Immingham Green Energy Terminal

9.3 Applicant's Responses to the Examining Authority's First
Written Questions

(Responses to "Q1.1. General and Cross-cutting")

Document Reference: TR030008/EXAM/9.3

LEGEND

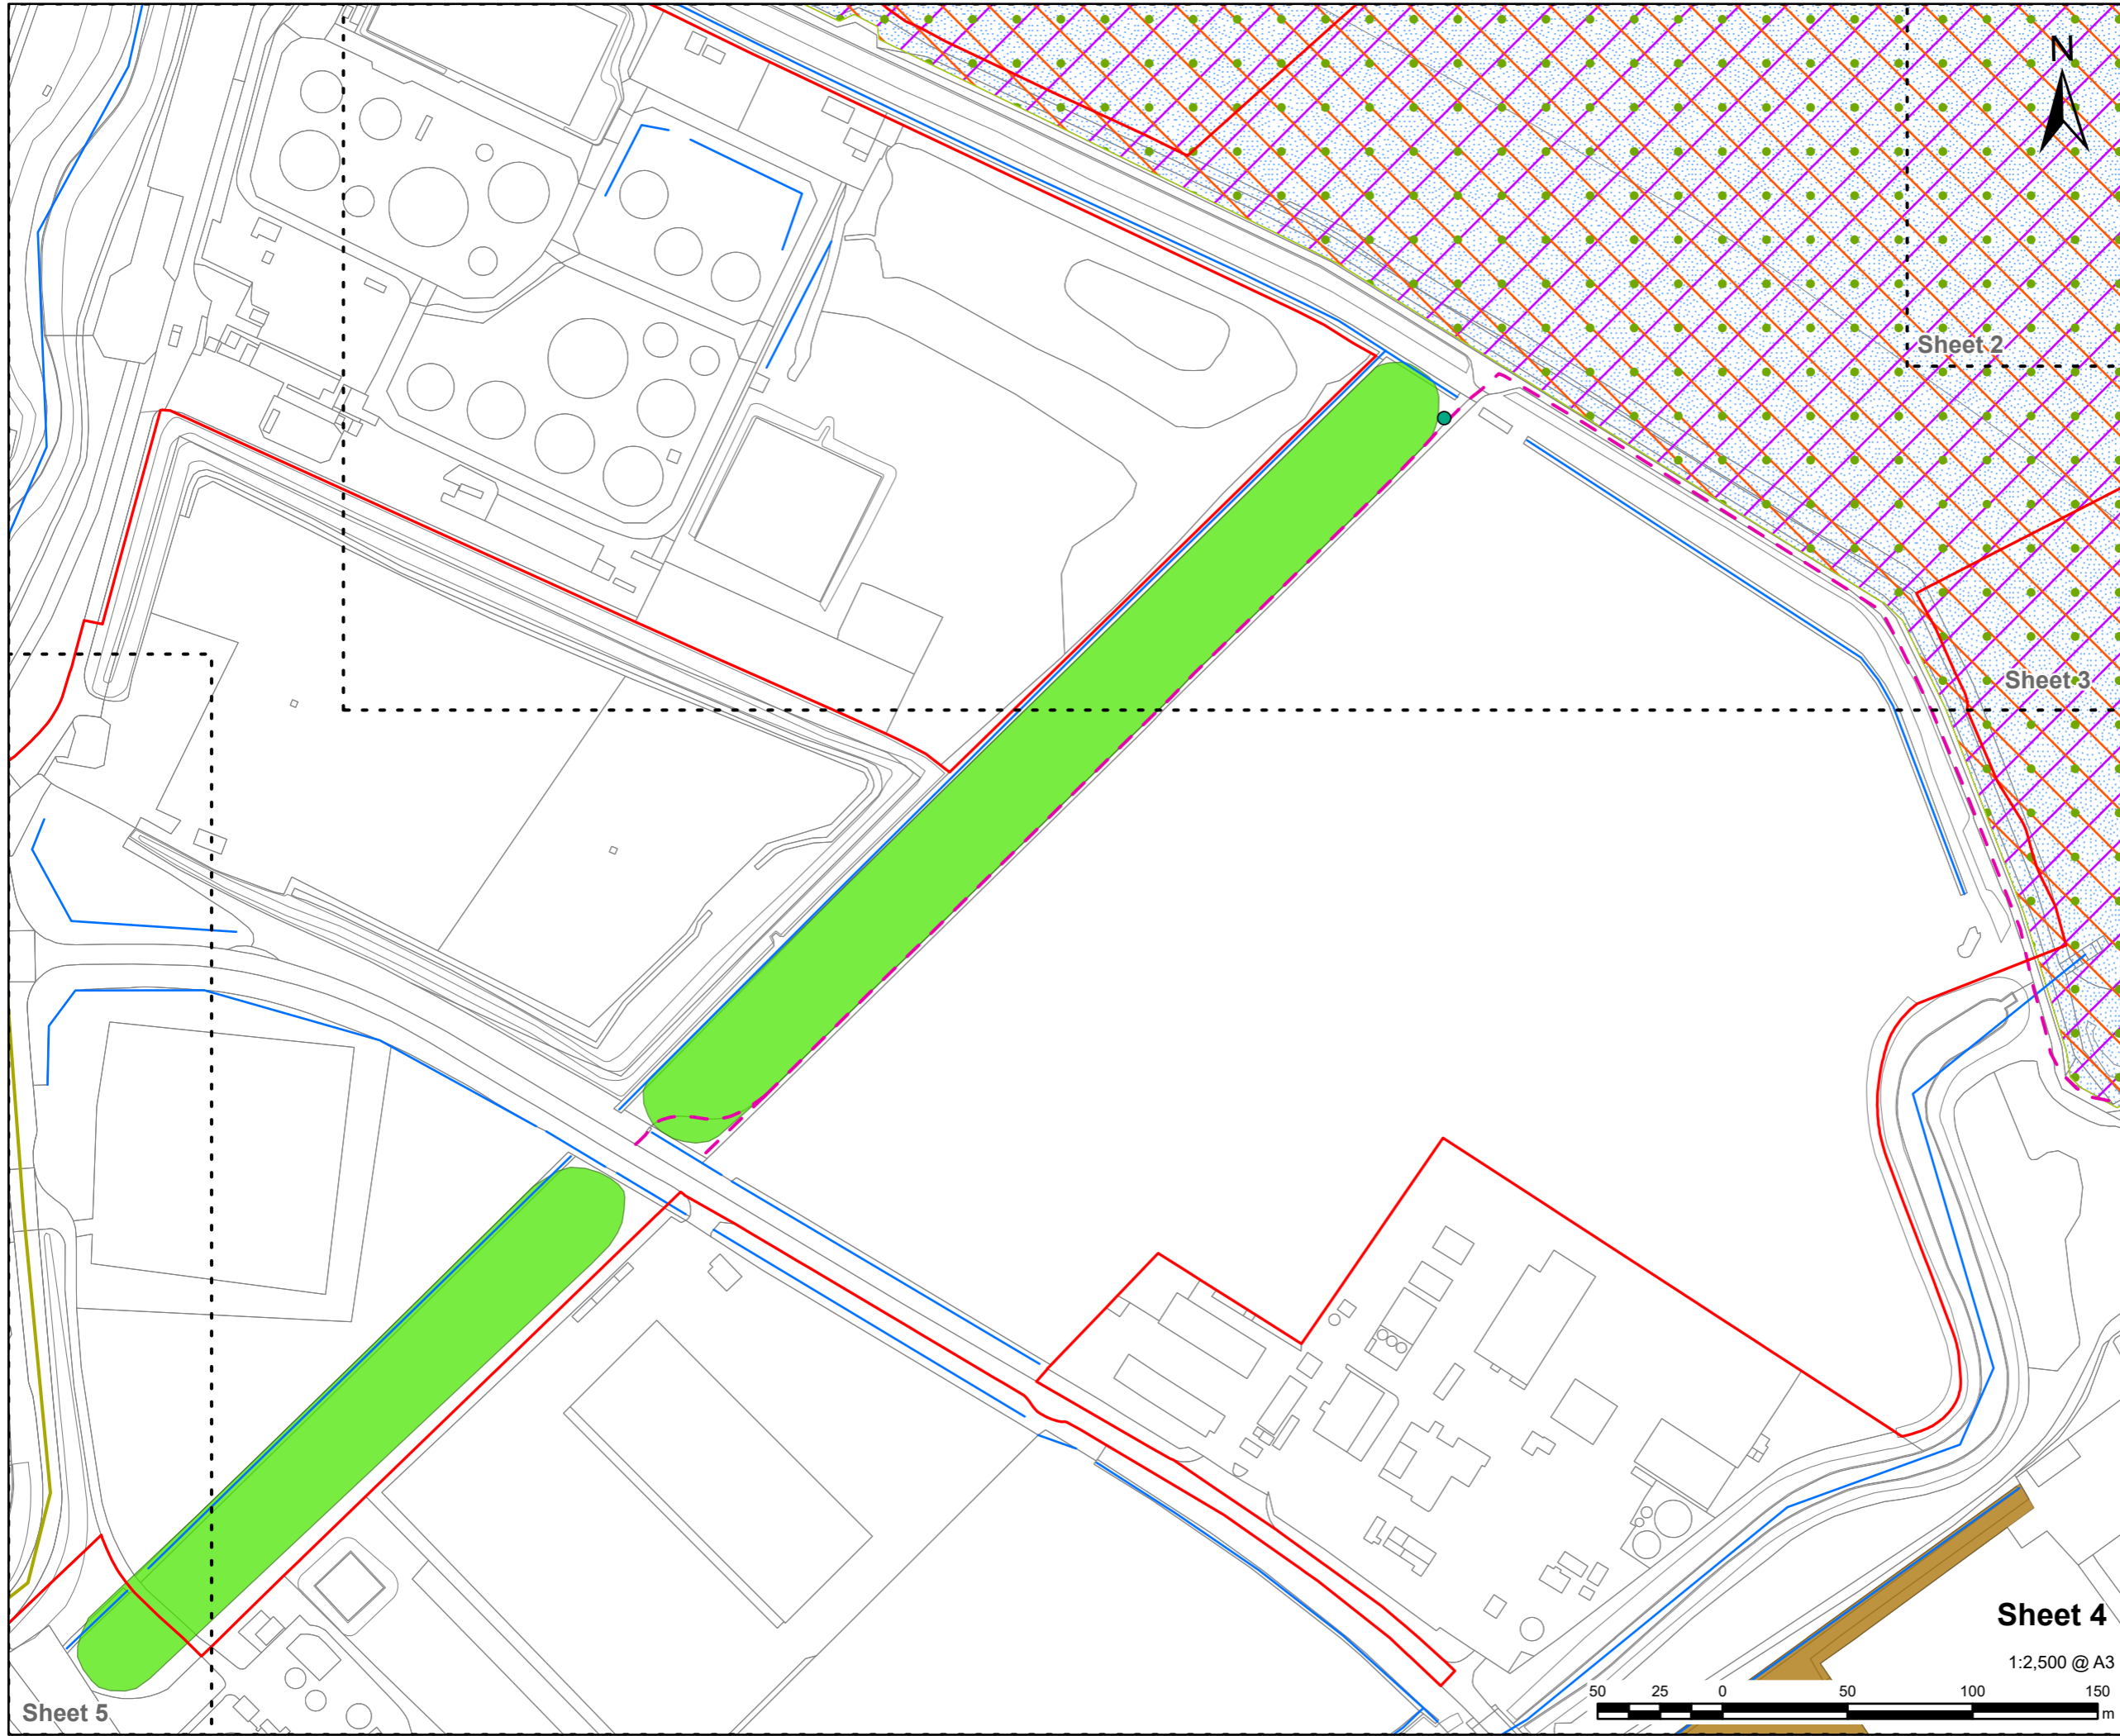
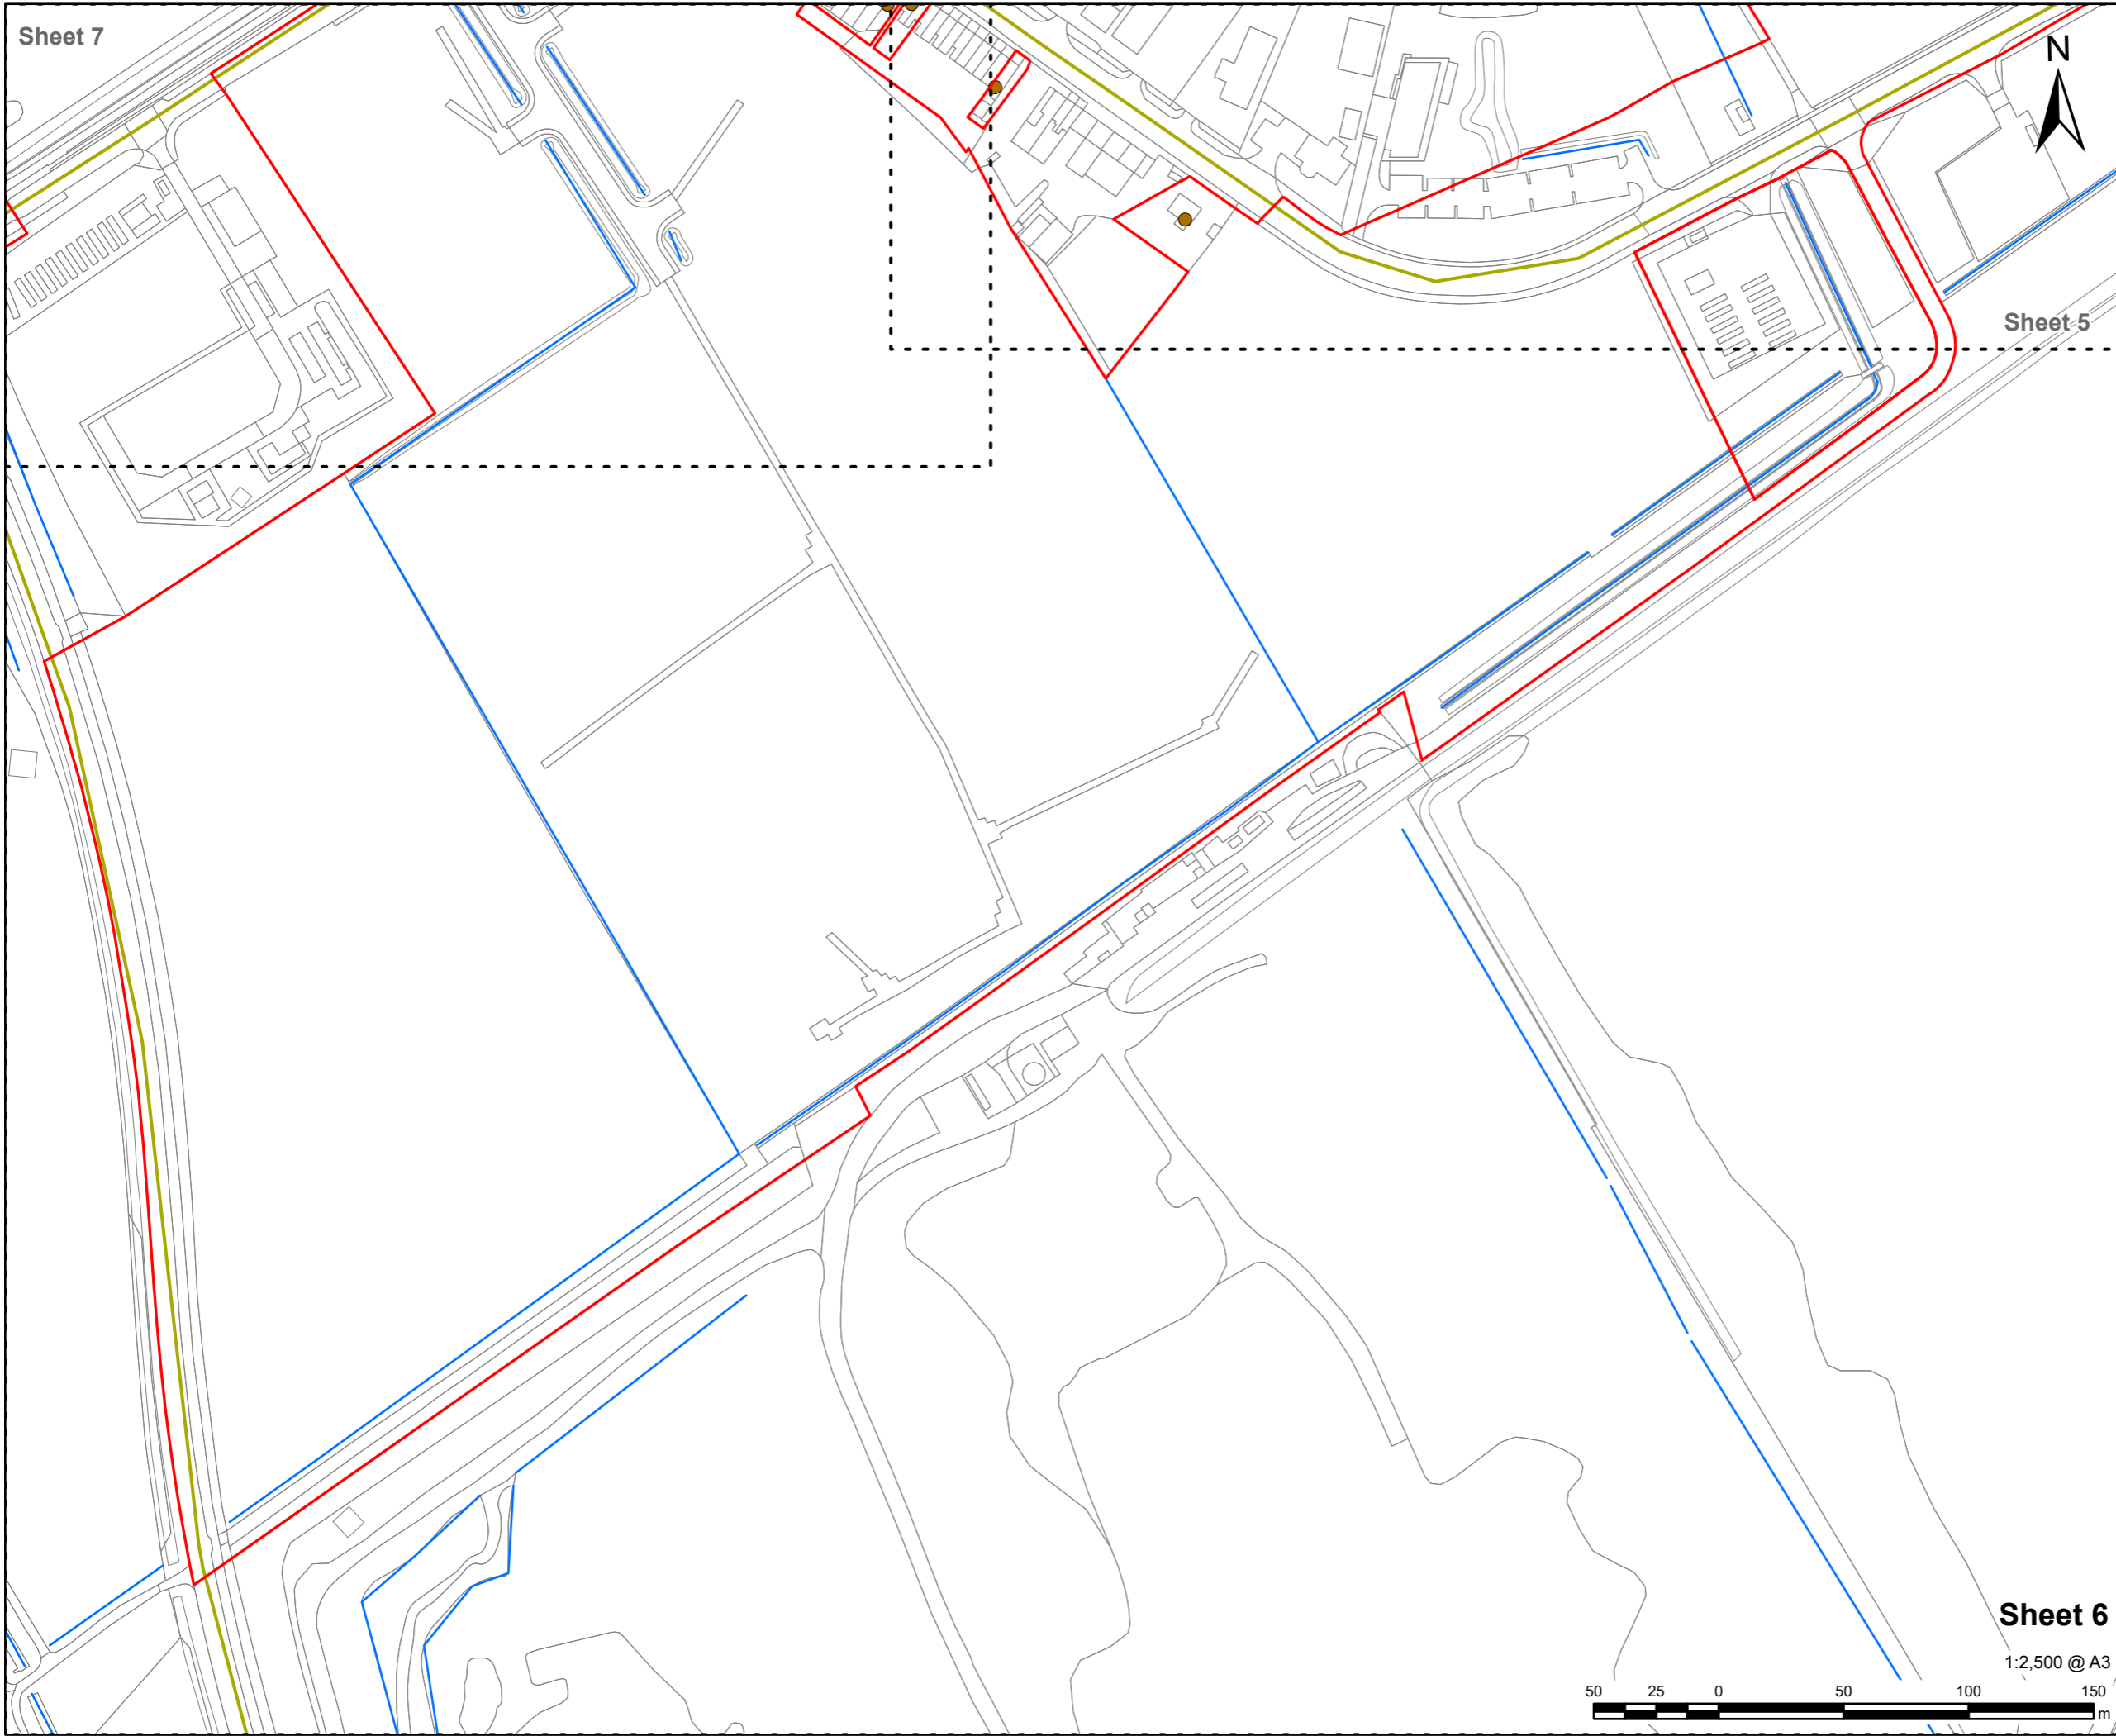
<p>Document Correction</p> <p>ES [APP-181, Appendix 8.B, Paragraph 2.3.14] states that the Long Strip south of Laporte Road is not included in the site boundary. However, it is included on all the site maps. Explain or clarify or correct this document.</p>	<p>The Long Strip south of Laporte Road is included in the Site Boundary. Paragraph 2.3.14 within ES Appendix 8.B: Preliminary Ecological Appraisal Report [APP-181] should state:</p> <p><i>“A narrow band of woodland approximately 40m in width located on the north side of Laporte Road; the same woodland band also continues south from Laporte Road and is essentially split into two halves by the road. Both sections of woodland are within the Site Boundary.”</i></p> <p>The Table of Errata [PDA-010] submitted at Procedural Deadline A also provides the corrected text.</p>
<p>Q1.1.1.4</p>	
<p>Question</p>	<p>Response</p>
<p>Transboundary</p> <p>Considering all aspects of the Proposed Development, would there be any issue which may affect transboundary matters or foreign countries? If so, what would be the magnitude of these impacts, and would these be adverse in nature?</p>	<p>The Planning Inspectorate undertook a transboundary screening for the purposes of Regulation 32 of the Infrastructure Planning (Environmental Impact Assessment) Regulations 2017 on 2 March 2023 following the Applicant's request for a Scoping Opinion.</p> <p>The Planning Inspectorate concluded that the Project is likely to have a significant effect on the environment in a European Economic Area (“EEA”) state, and subsequently Denmark and Iceland were notified of the Project. The reason for notification related to the potential impacts on bird populations of conservation importance.</p> <p>The Planning Inspectorate published a second Transboundary Screening on 1 February 2024, concluding that no new EEA states had been identified as being likely to have significant effects on their environment. On a precautionary basis, Iceland would be notified of the Project and Denmark would be consulted as they had requested to be involved in the transboundary consultation.</p>
